Application Ref:	3/2019/0946	 Ribble Valley Borough Council www.ribblevalley.gov.uk
Date Inspected:	17/12/19	
Officer:	SK	
DELEGATED ITEM FILE REPORT:		REFUSAL

Development Description:	Formation of dormer to rear of property and conversion of existing loft to create two new dwellings (one one-bedroom studio and one two-bedroom flat).
Site Address/Location:	Waterloo House 62-64 Waterloo Road Clitheroe BB7 1NS

2nd Floor Layout

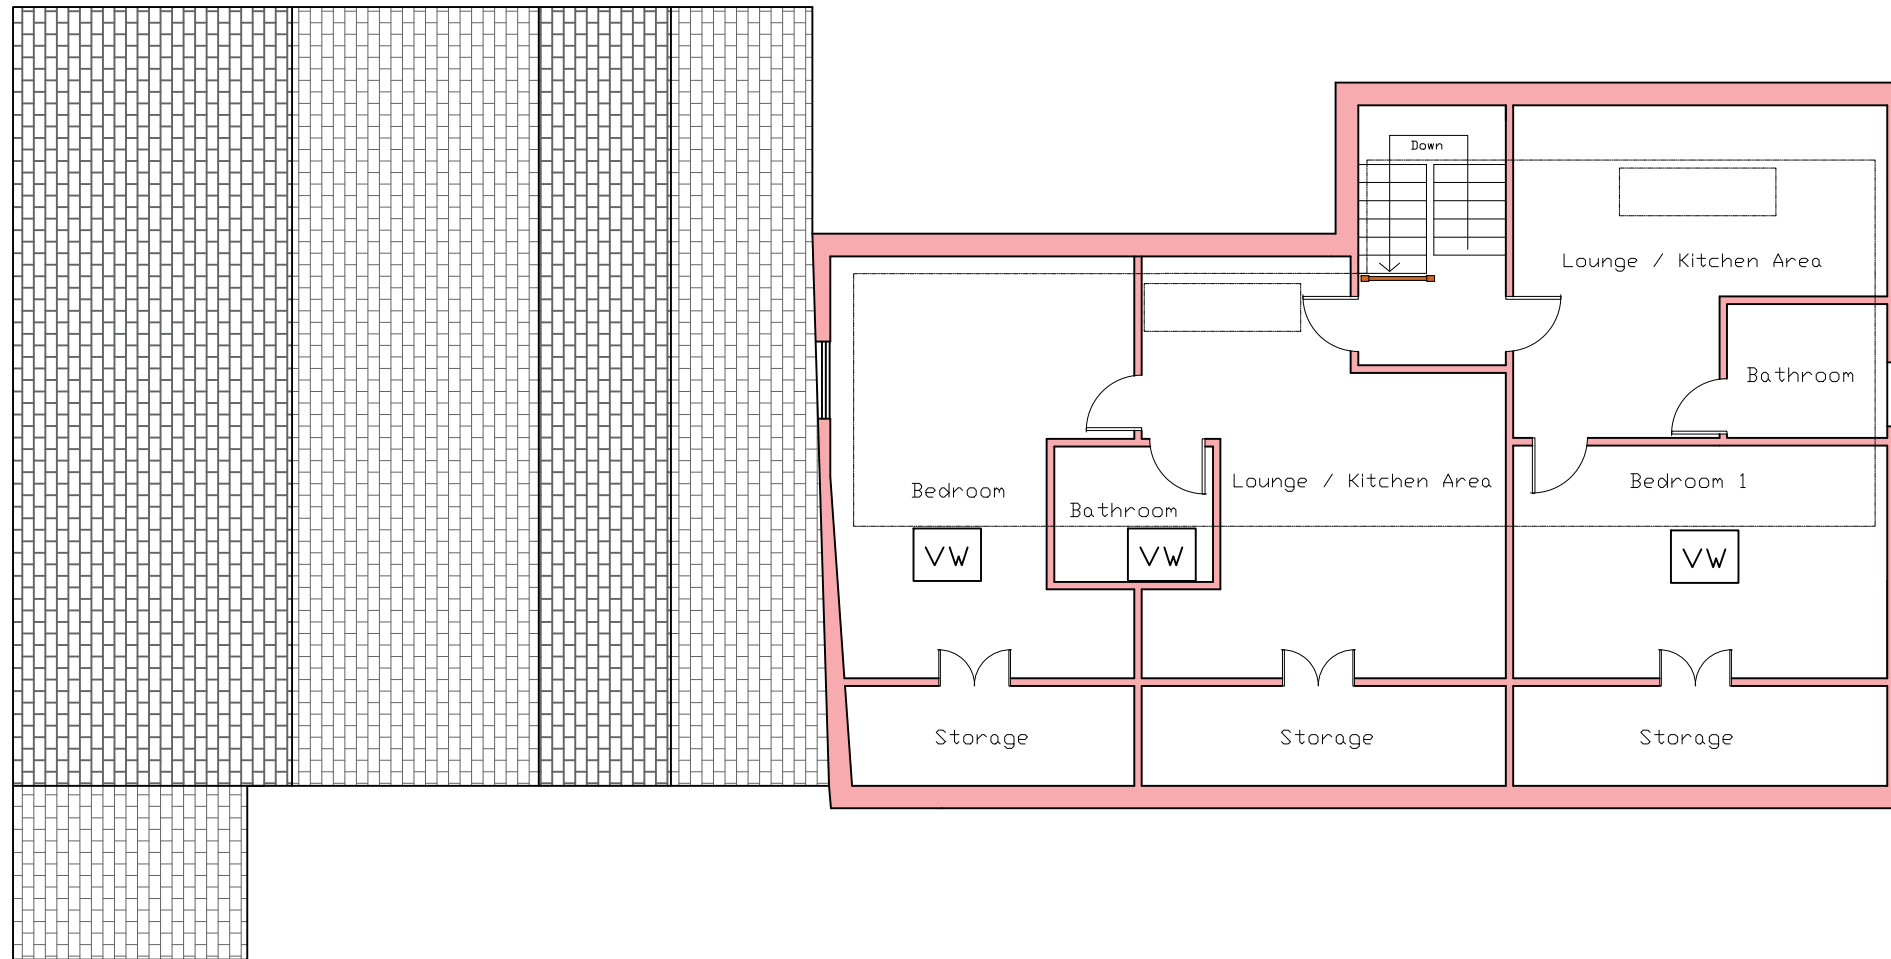
The dormer will accommodate 3 south-easterly windows that will serve two living room/lounges and a communal stairwell.

In respect of the above it is noted that the applicant states that the windows to be located on the dormer will be installed with *'fixed horizontal slats to impair the vision of residents'* to counter any perceived overlooking issues. However, no details have been provided in respect of the 'privacy slats' or 'louvres'. Notwithstanding this matter, it is not considered that such devices could reasonably operate to a level that would fully mitigate the potential for direct over-looking. Even if such devices could be successfully implemented it is considered that they are likely to impair the outlook for potential residents of the apartments to a degree that would result in an unacceptable level of residential amenity by virtue of the lack of an adequate outlook.

Roof Plan

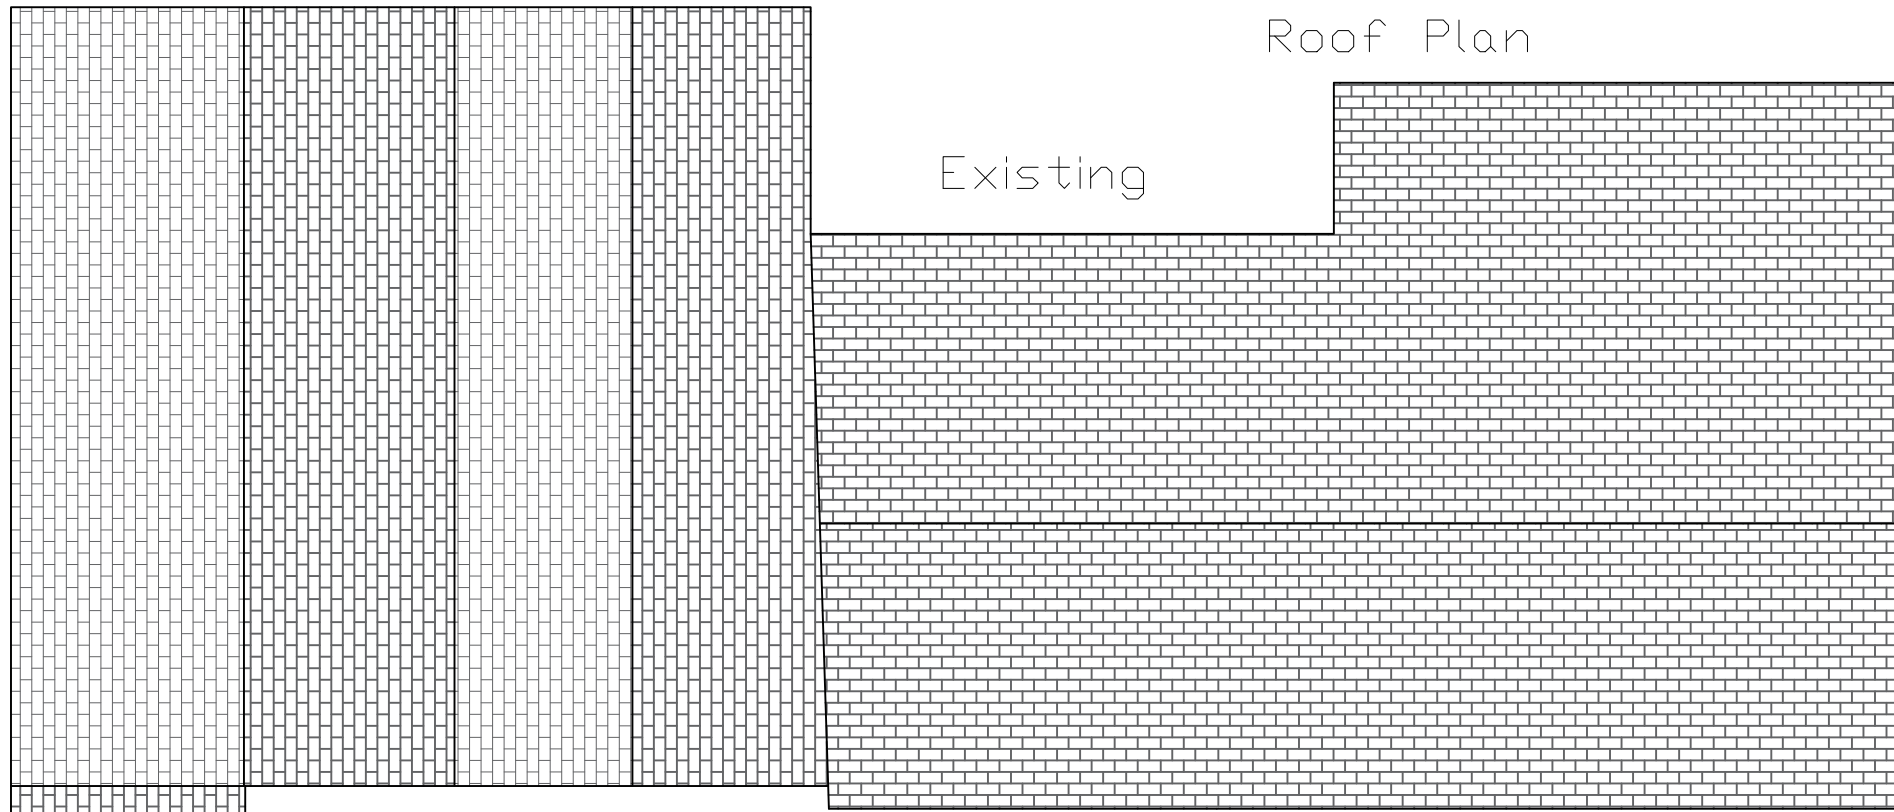
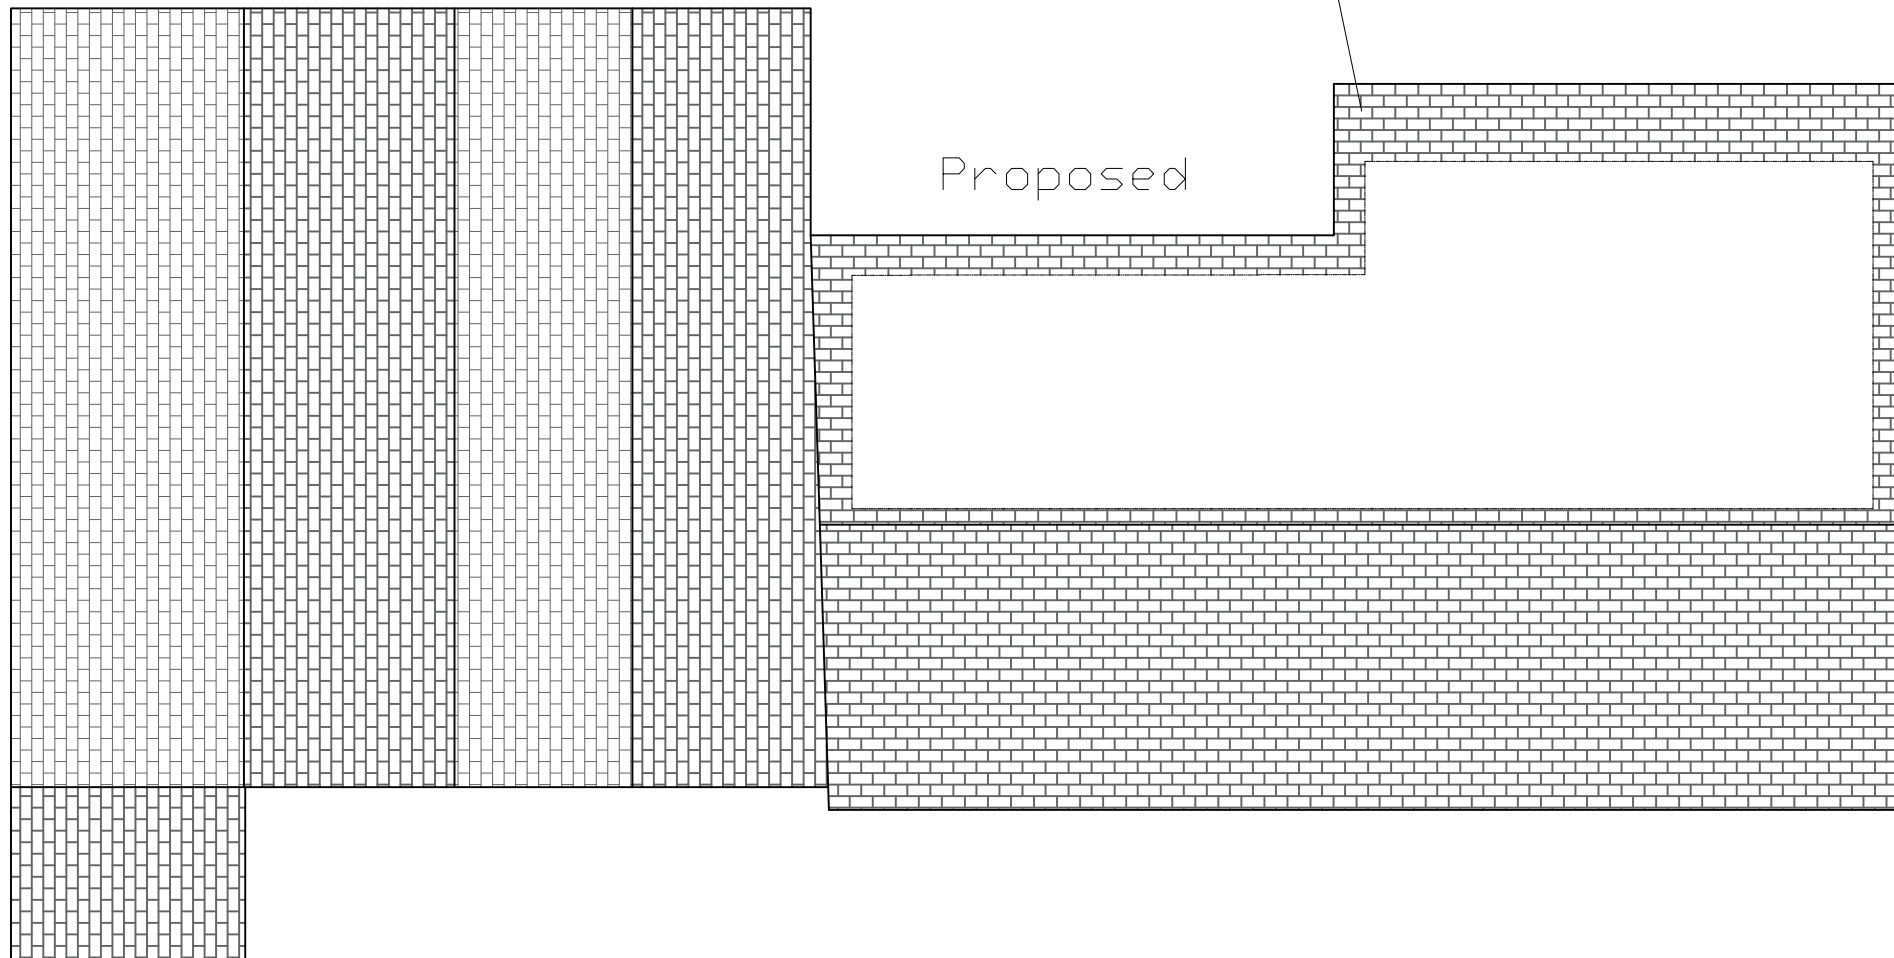
The dormer will measure 13m in width and be of a height of approximately 2.35m at its highest point. The dormer will be set below that of the existing ridgeline by approximately 200/300mm and be set back from the primary wall-plate by approximately 300/400mm.

Side Elevations

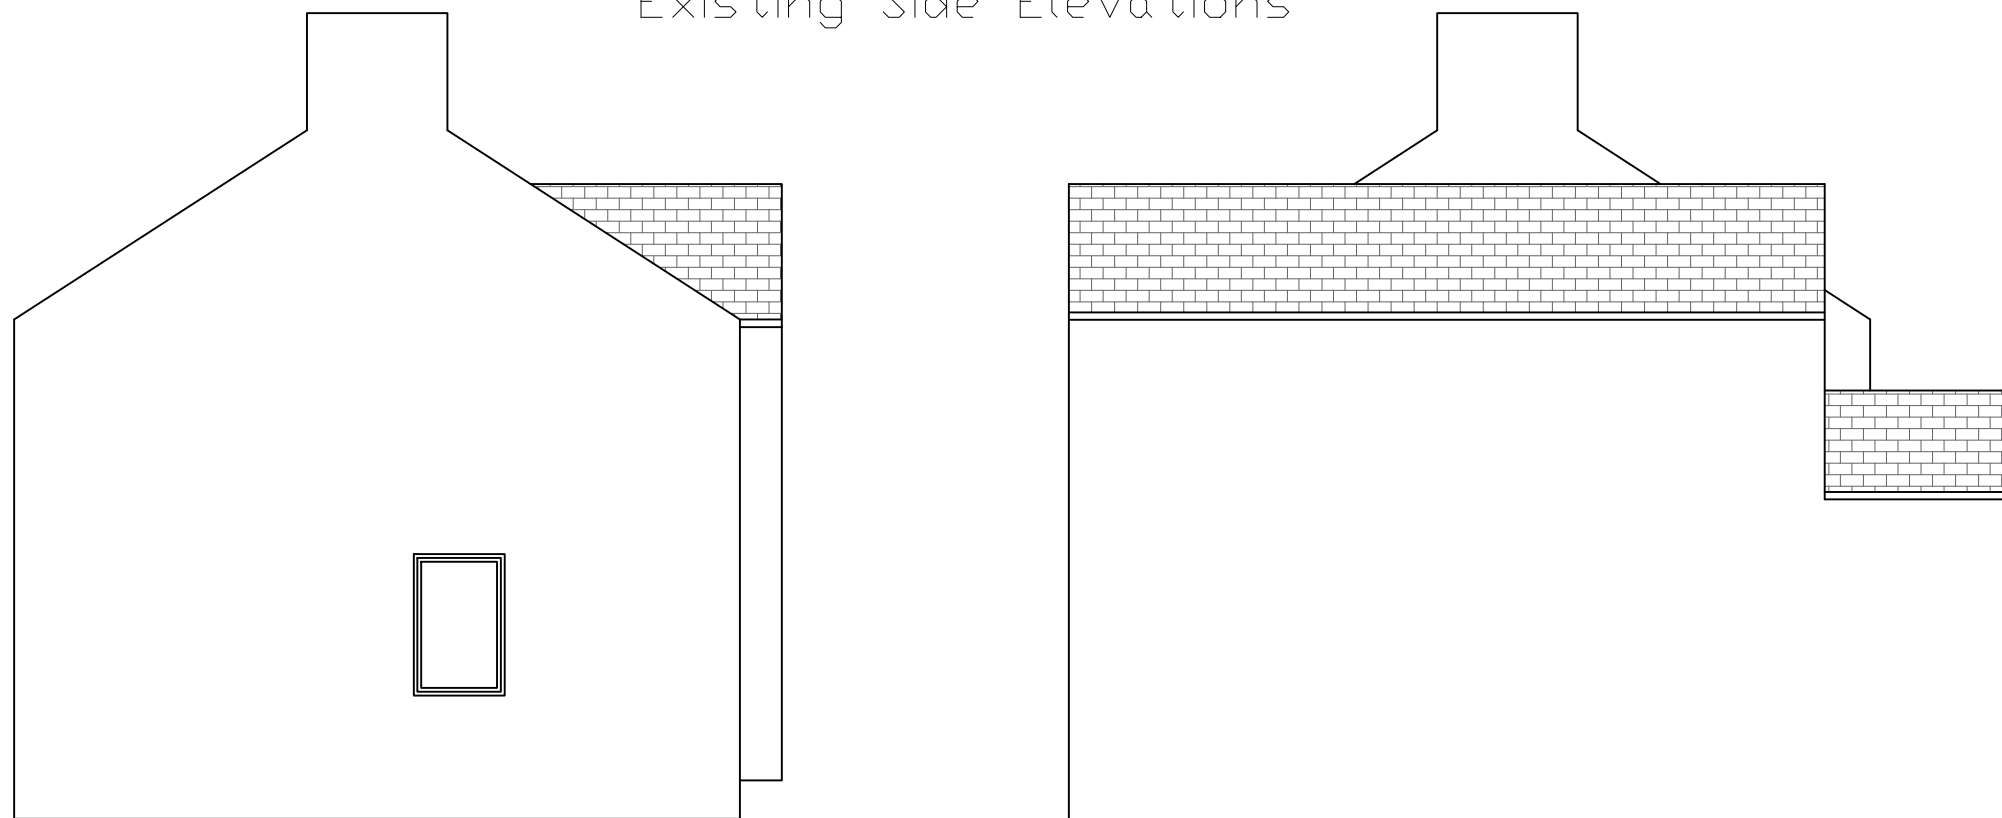
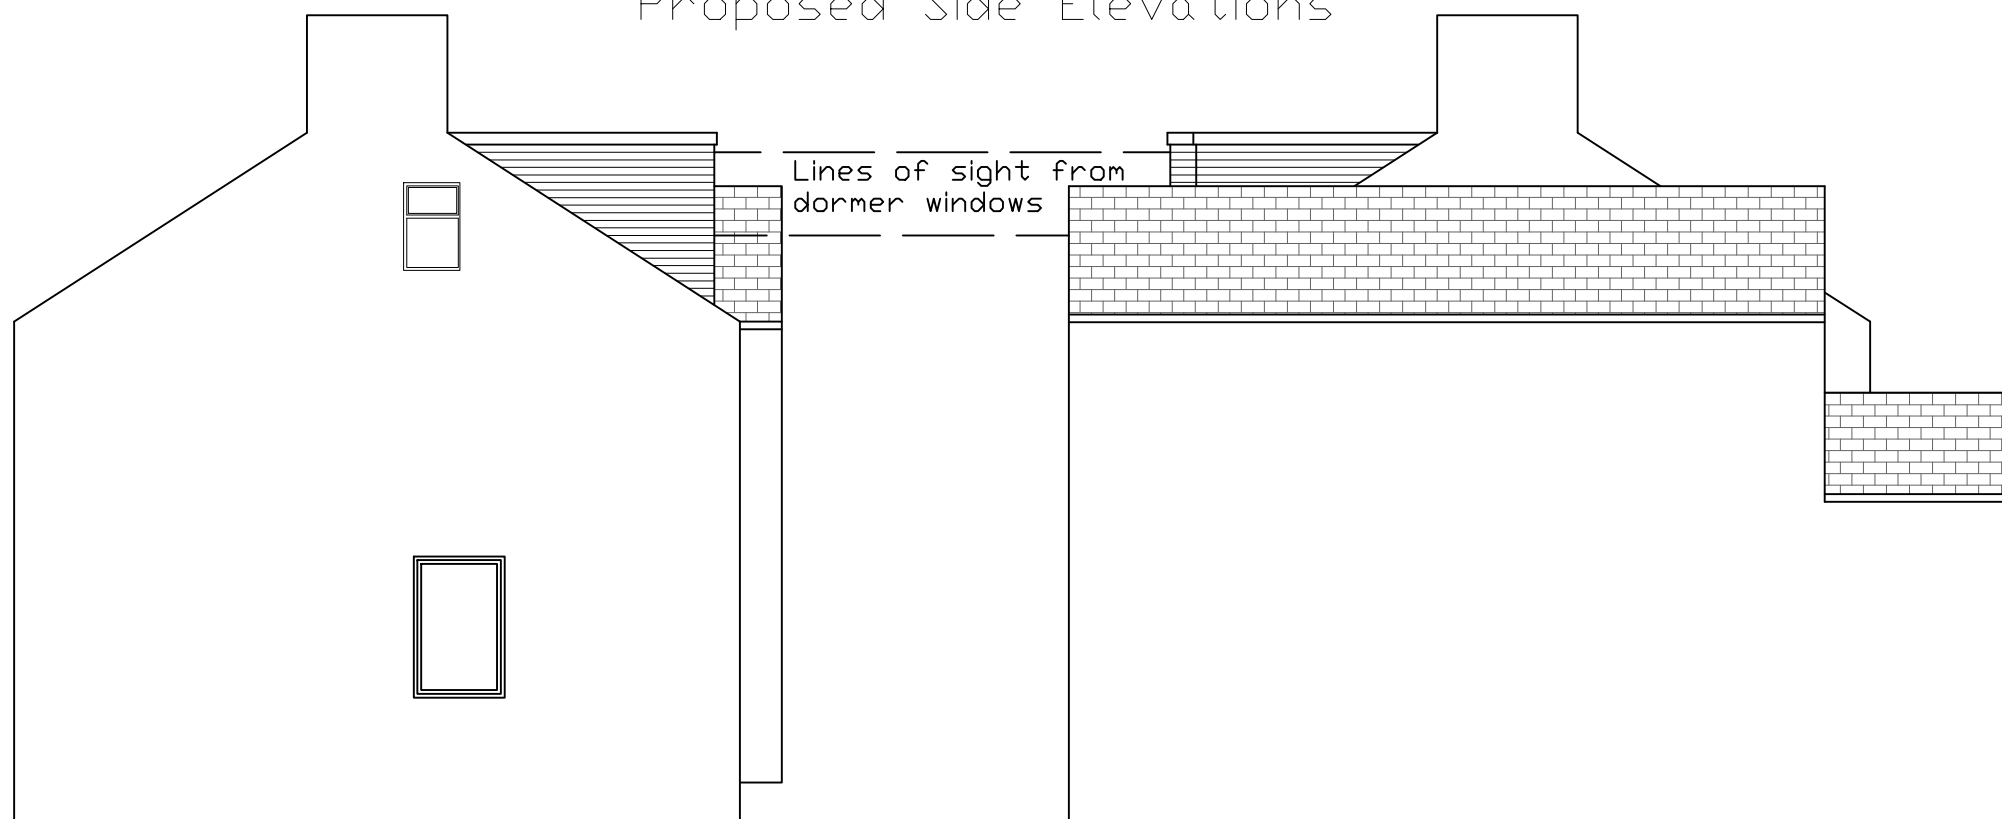
The proposed dormer will benefit from a south-easterly outlook directly over the private residential curtilage associated with number 45 River Lea Gardens within a proximity of approximately 3m. From undertaking a site visit and viewing the location of the proposed dormer from the affected property, it is clear that the residential amenities of the occupiers of number 45 have to some degree already been compromised, largely due to the presence of a number of windows on Waterloo House that currently directly overlook the dwellings garden area.

However, the presence or existence of harm or undue impact does not warrant the further exacerbation of such impacts nor can it be considered as sufficient justification to warrant further harm. In this respect it is considered that the proposed dormer will result in an unacceptable level of over-looking of neighbouring private amenity space. It is further considered that such impacts, when considered cumulatively in concert with the number of windows on the host property that already overlook number 45, that the introduction of the dormer would significantly undermine and cause significant undue harm to neighbouring residential amenity due to a severe erosion of the sense of privacy currently felt by the occupants of number 45.

In addition to the above matters it is further considered that the proposed dormer, by virtue of its overall scale, mass and proximity to the shared boundary with number 45 River Lea Gardens, would result in an unacceptable overbearing and over dominant impact upon the aforementioned dwelling due to the overall cumulative mass of built-form directly adjacent the dwellings garden area.

By virtue of the inherent staggered building-line in the area and the forward projection of Waterloo House compared to that of neighbouring buildings, it is likely that the south-western facing elevation of the dormer will be visible upon approach from the south along Waterloo Road.

The roof-scape in the surrounding area is largely unaltered, consisting predominantly of gabled roof forms. In this respect it is considered that the dormer will appear somewhat anomalous and discordant. However, taking account of the limited views that will be afforded to the dormer it is not considered that the negative impacts upon the character or visual amenities of the area would be so severe as to warrant the refusal to grant planning permission on these grounds alone.

01 The proposed development is considered to be contrary to Policy DMG1 of the Ribble Valley Core Strategy insofar that approval of the proposed dormer would result in an unacceptable level of direct-overlooking of private residential amenity space, from an elevated position, within close proximity being of significant detriment to the amenities of existing neighbouring occupiers.

02 The proposed dormer, by virtue of its overall cumulative scale and proximity would result in a significant overbearing and over dominant impact upon number 45 River Lea Gardens, being of detriment to the residential amenities of existing and future occupiers of the dwelling. As such the proposal is considered to be in direct conflict with the aims and objectives of Policy DMG1 of the Ribble Valley Core Strategy.
